**WEST SUSSEX COUNTY COUNCIL
05/03/2018
COUNTY HIGHWAYS CONSULTATION RESPONSE**

SUBJECT: LY/28/17/PL - Change of use of existing building from farm shop & cafe to a brewery tap room (bar), fresh coffee bar & cafe & retail space.

Crossbush Farm Shop, Lyminster Road, Lyminster, West Sussex, BN17 7QN

Existing and Proposed Plans and Elevations

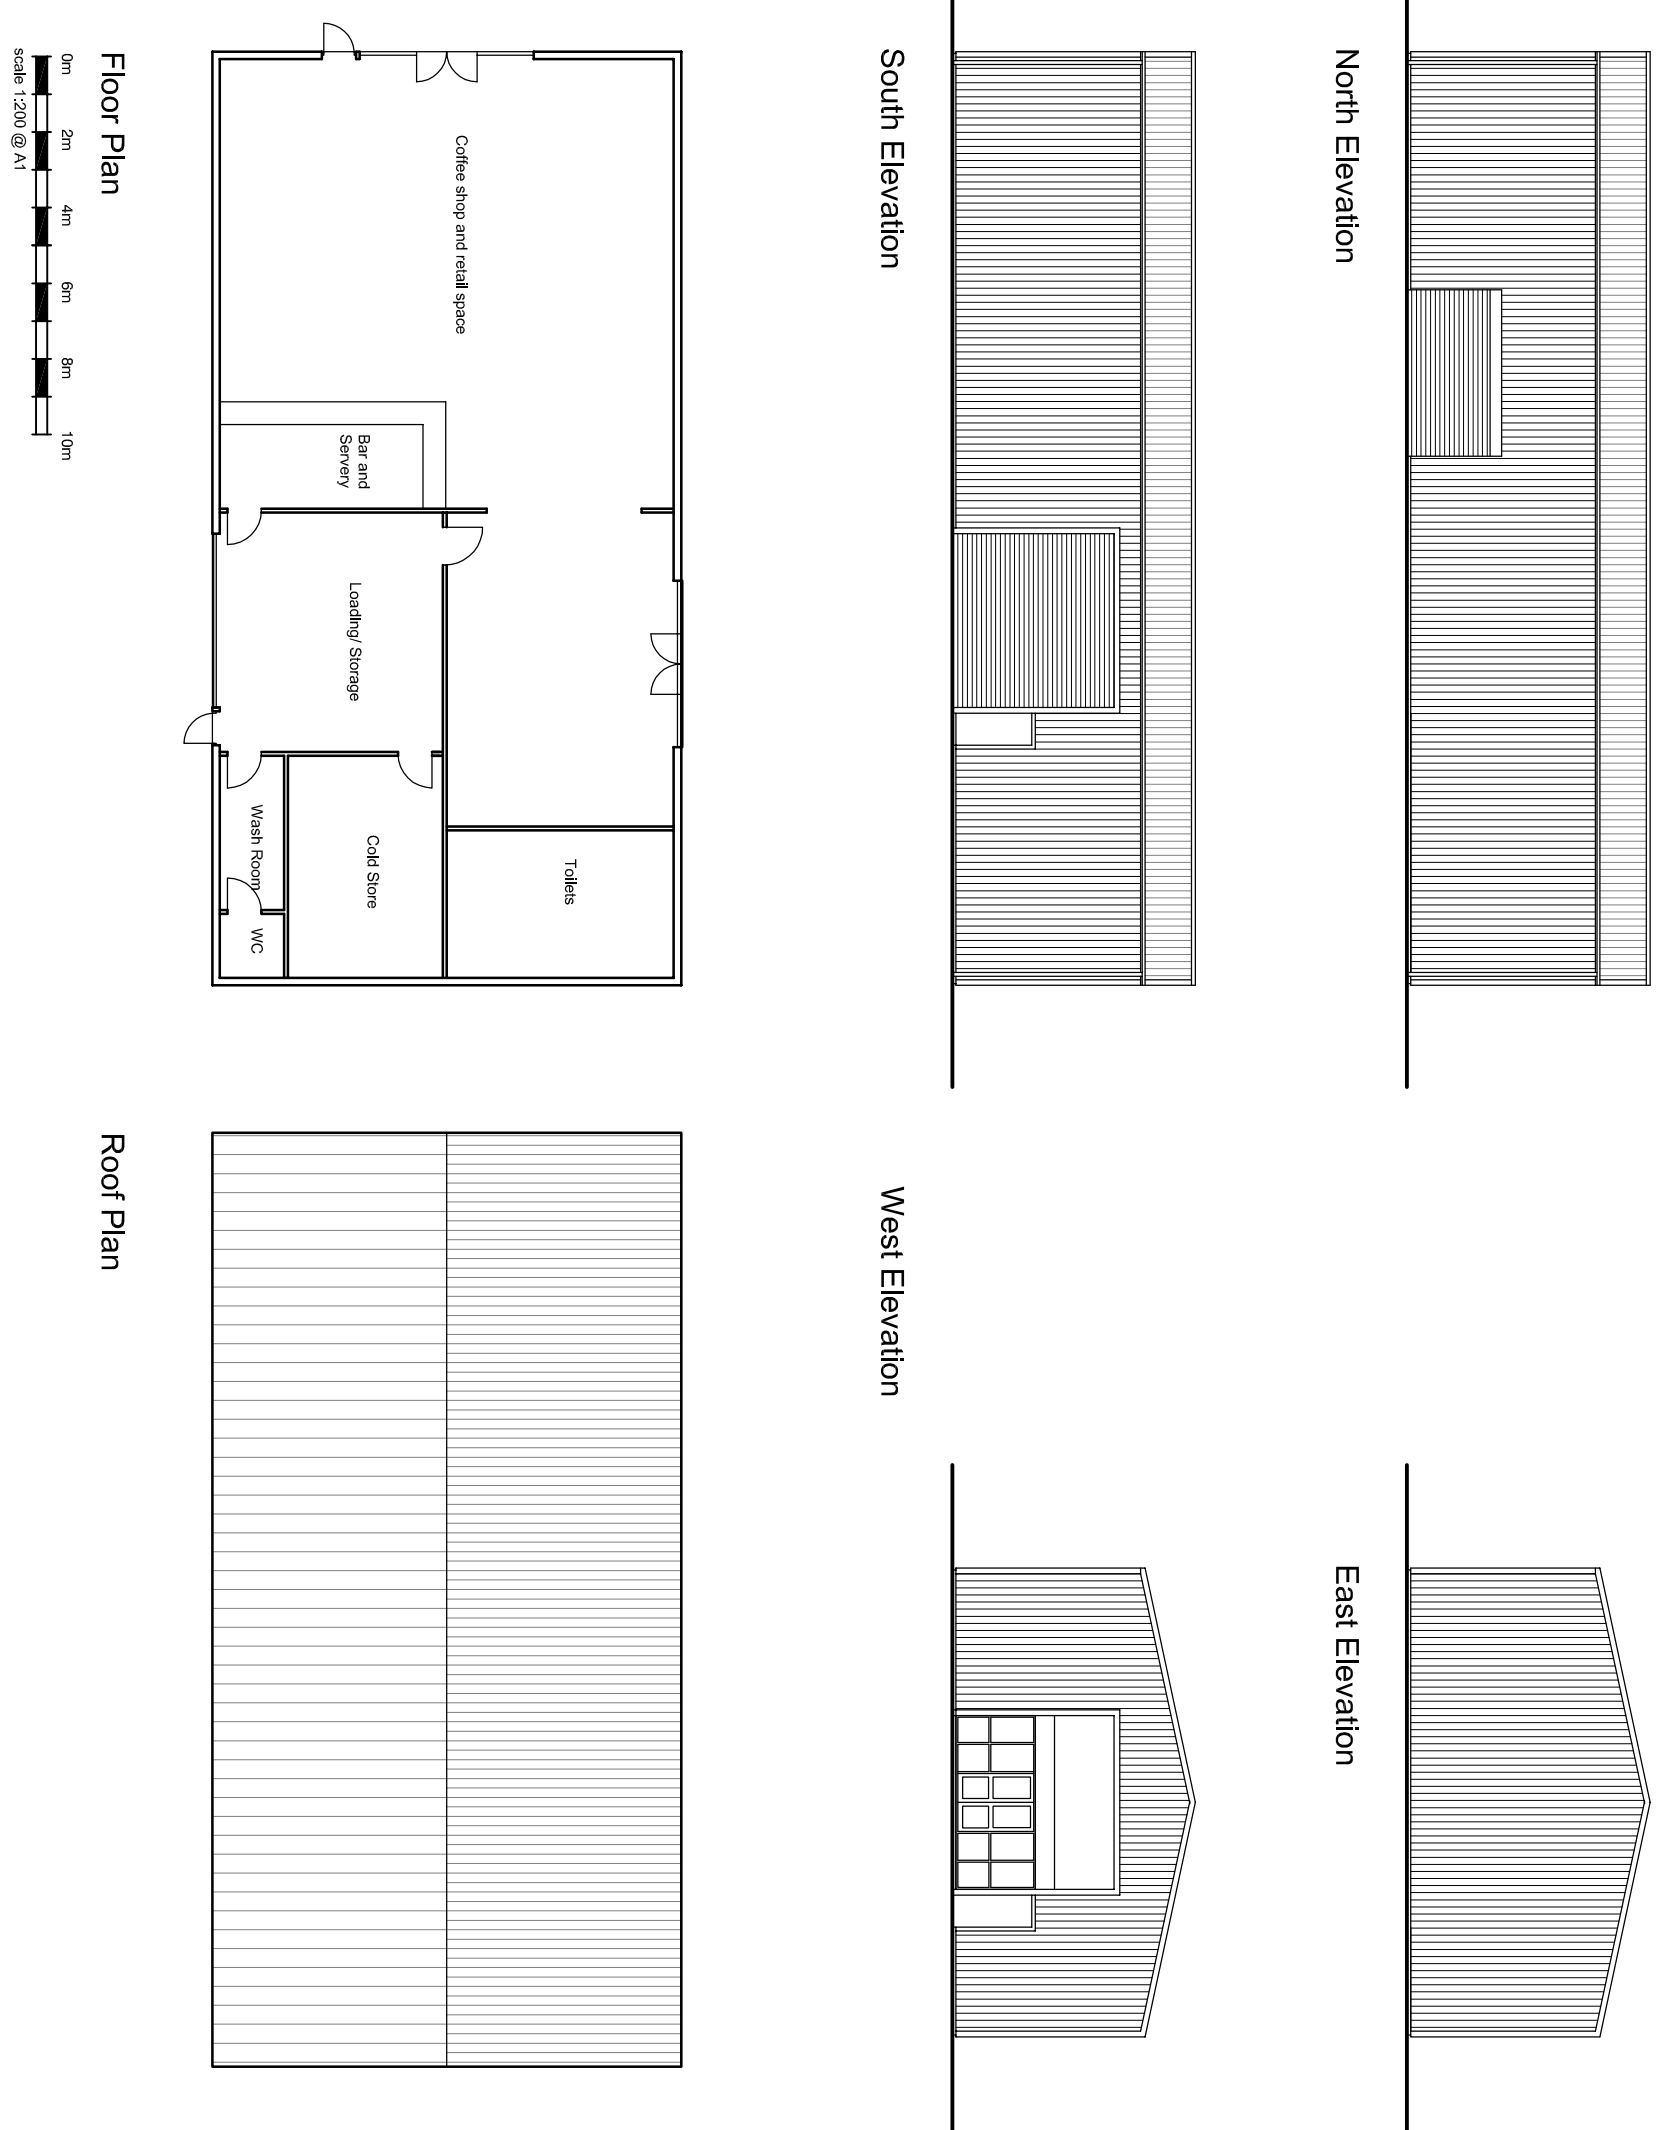
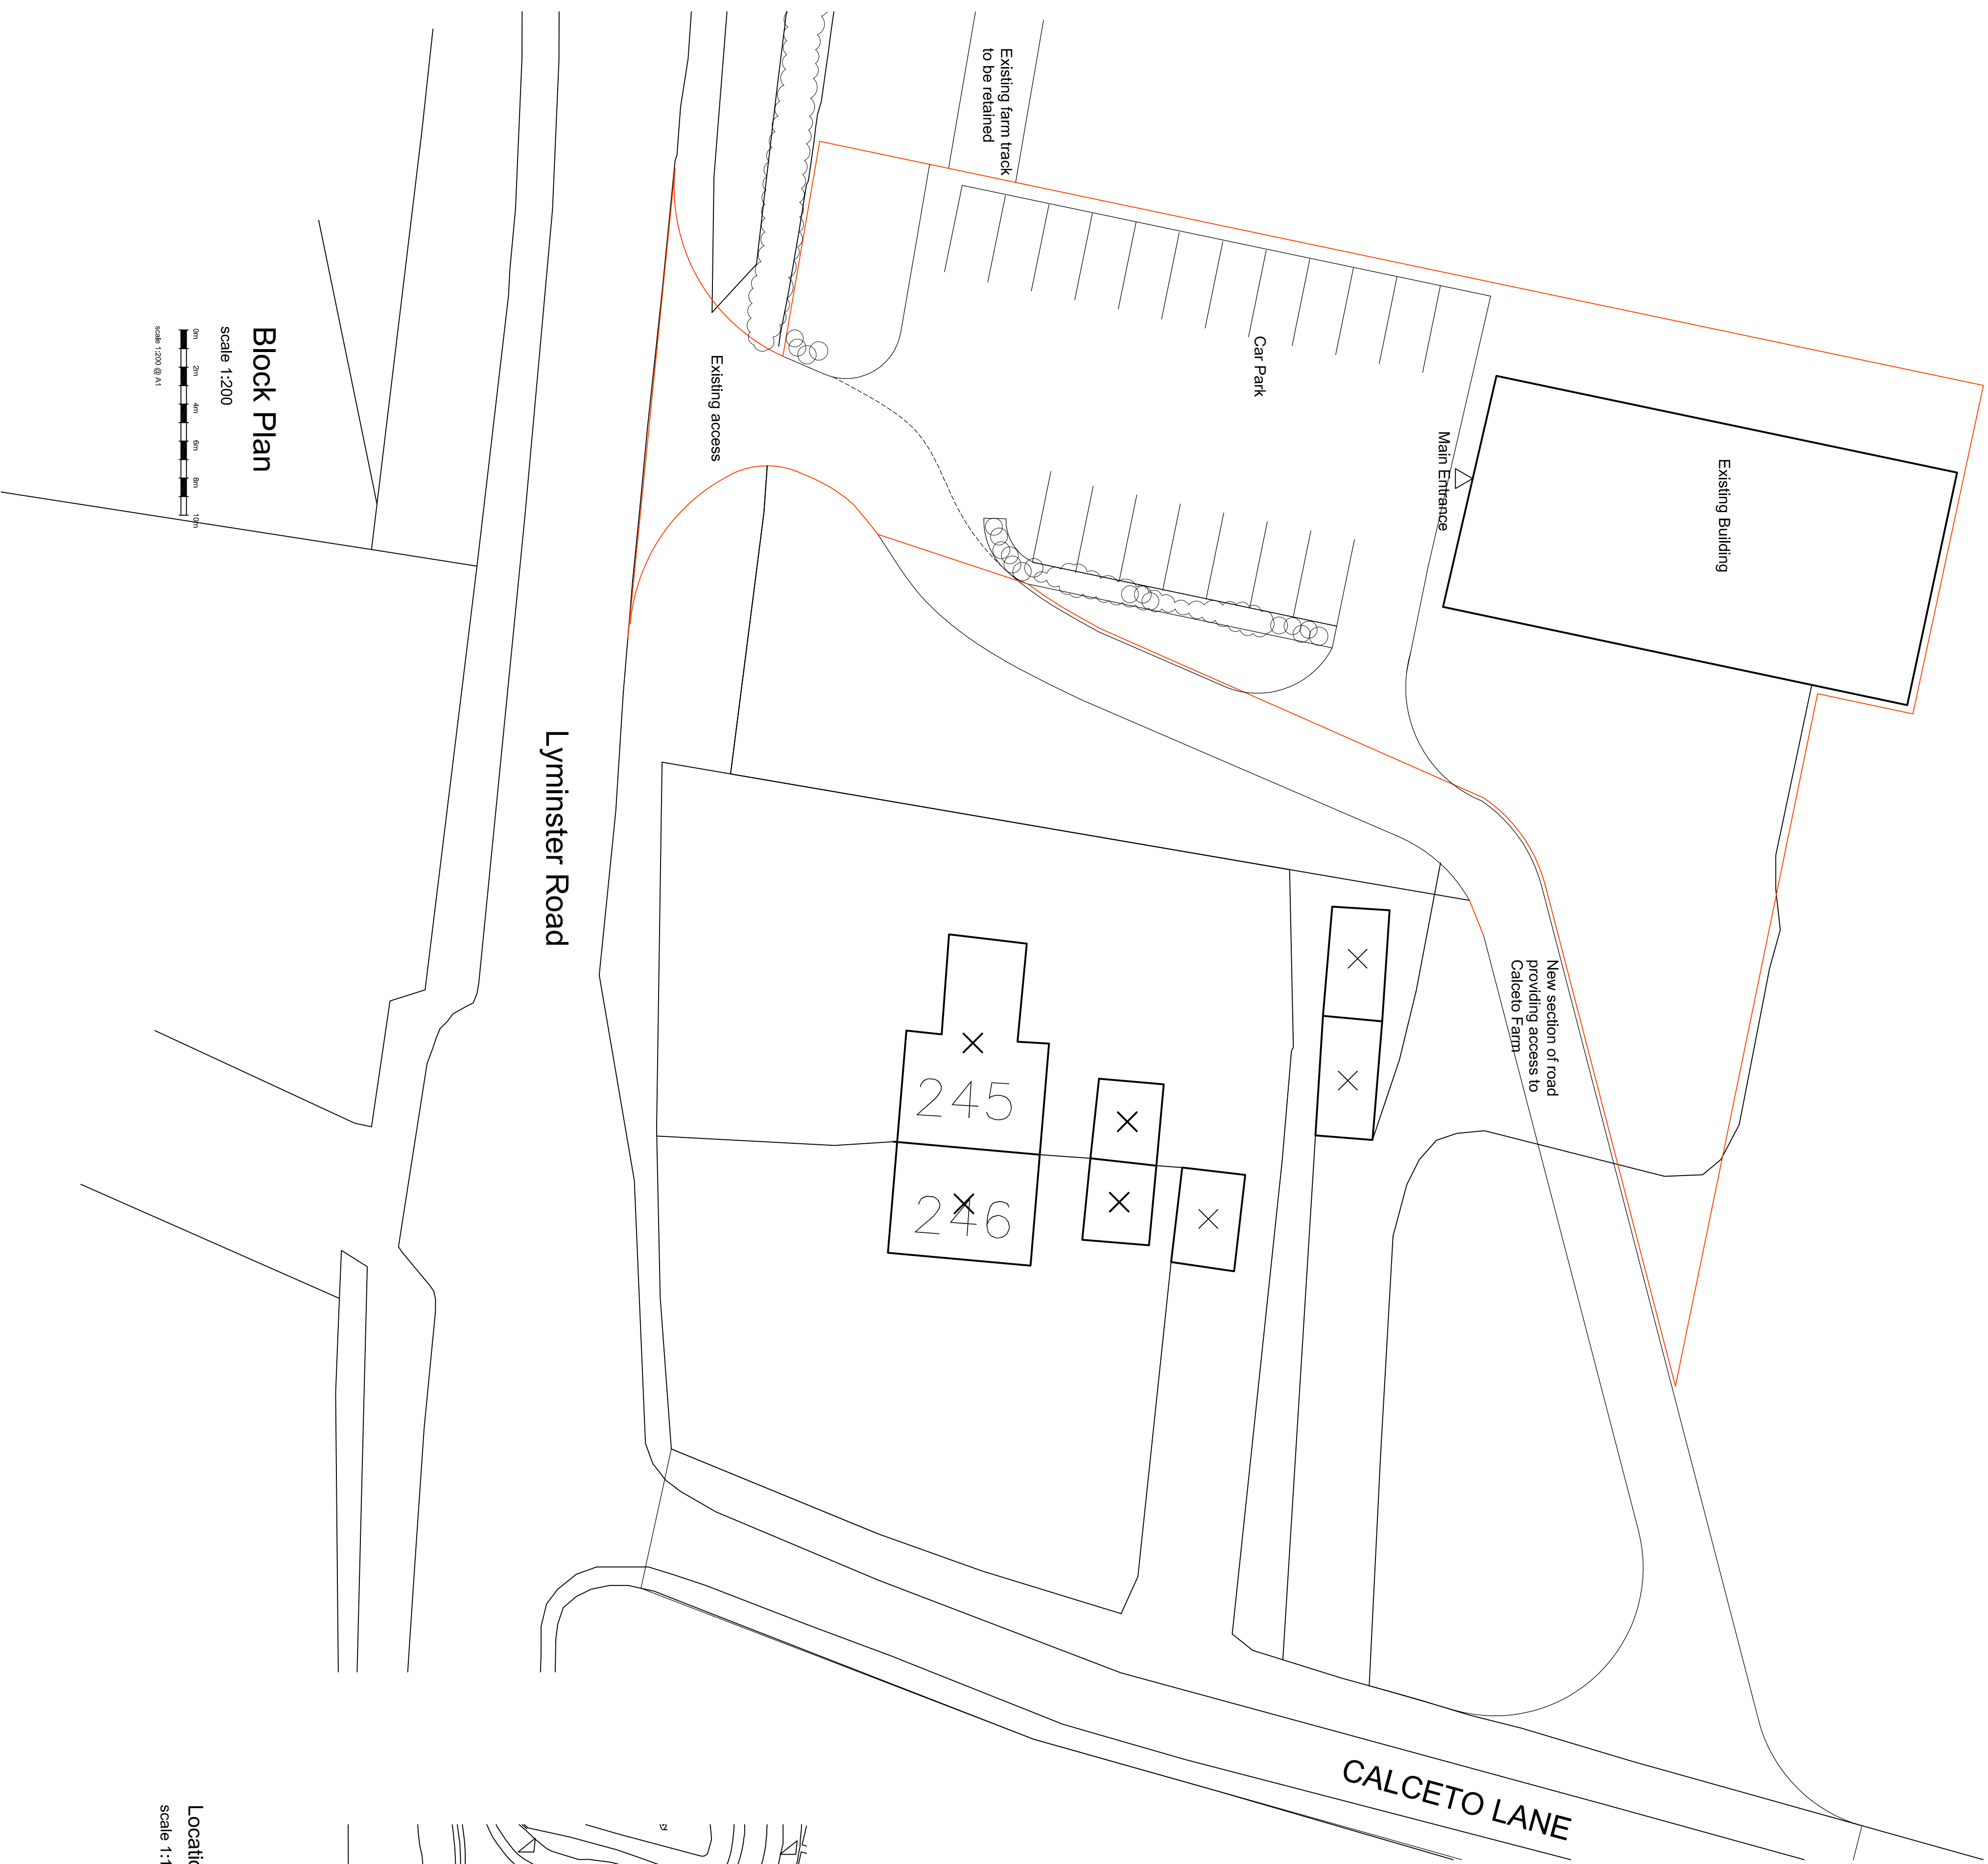
The latest block plan does not show the access closure works on Calceto Lane to remove access by motor vehicles, as approved under LY/14/11. Have these works been implemented? Is this proposed as part of this application?

The plans do not show any improvement works to the main access point onto Lyminster Road which were previously approved under LY/14/11.

The applicant should clarify if these works are to be included (and therefore secured) as part of this planning application, if so plan and details demonstrating them should be submitted.

Block Plan
scale 1:250 @ A1

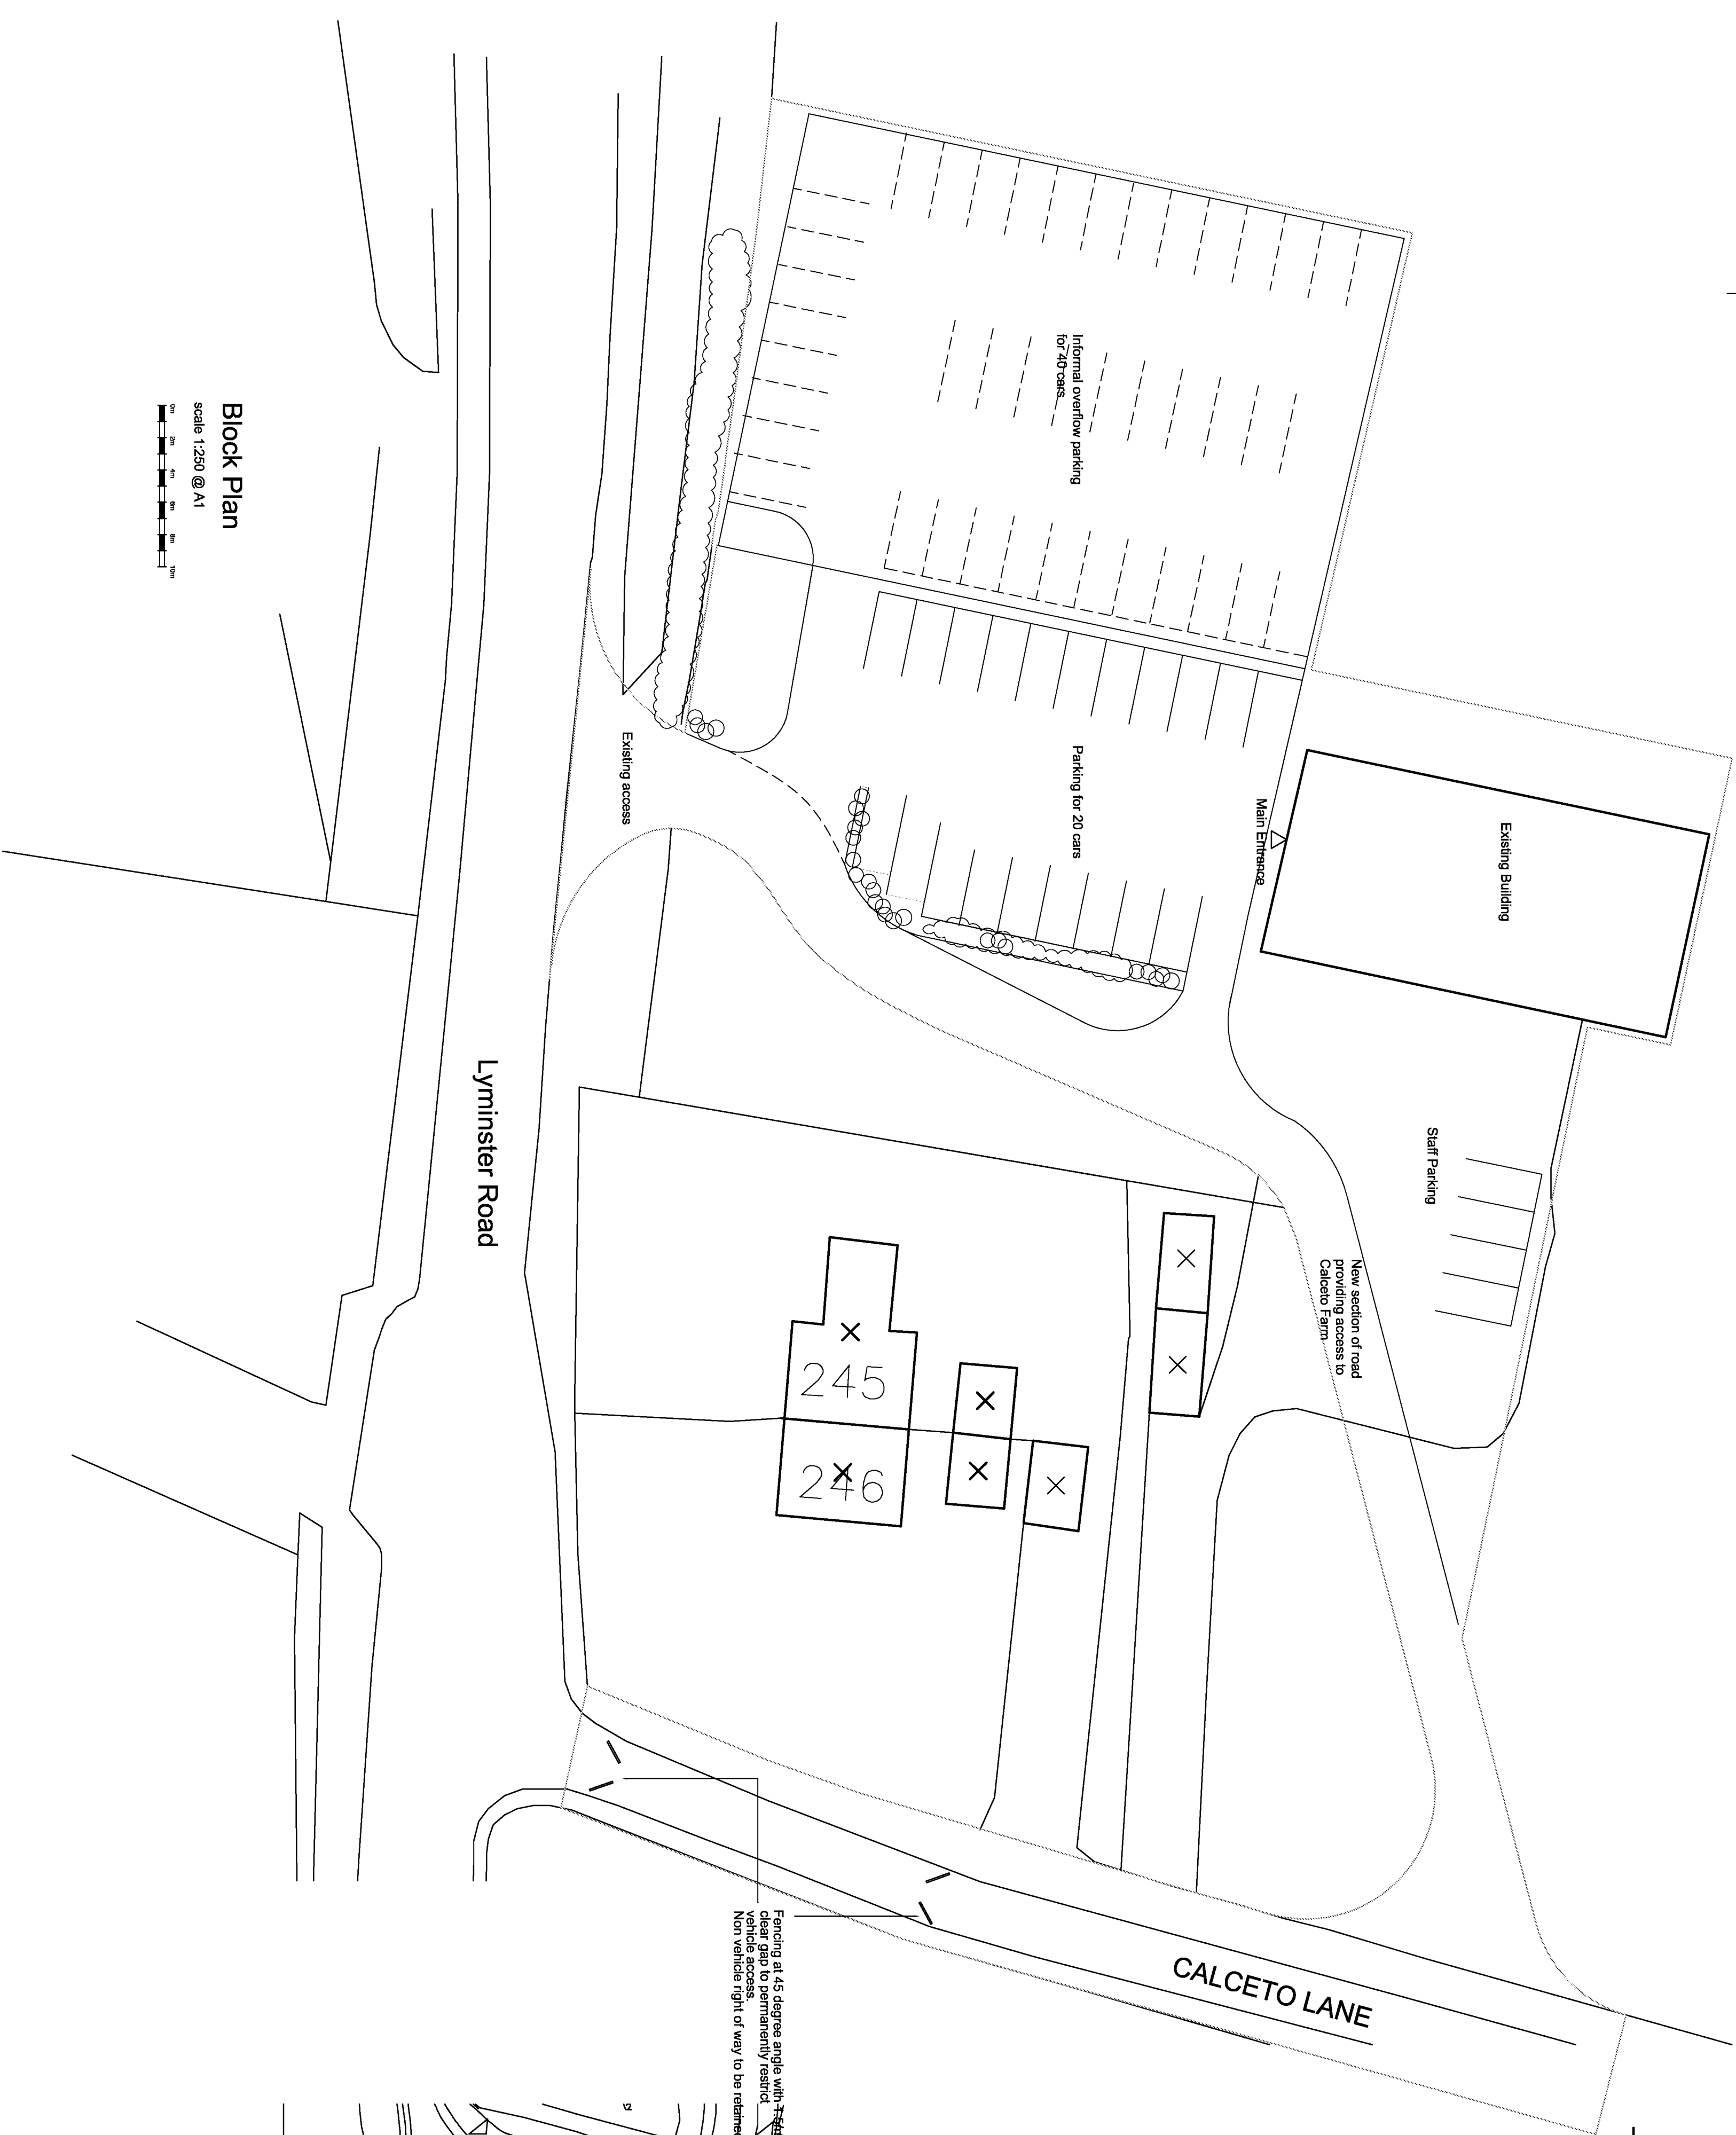
18 car parking spaces will be retained to serve the proposed use.

The applicant should provide additional details to justify this significant shortfall in car parking provision.
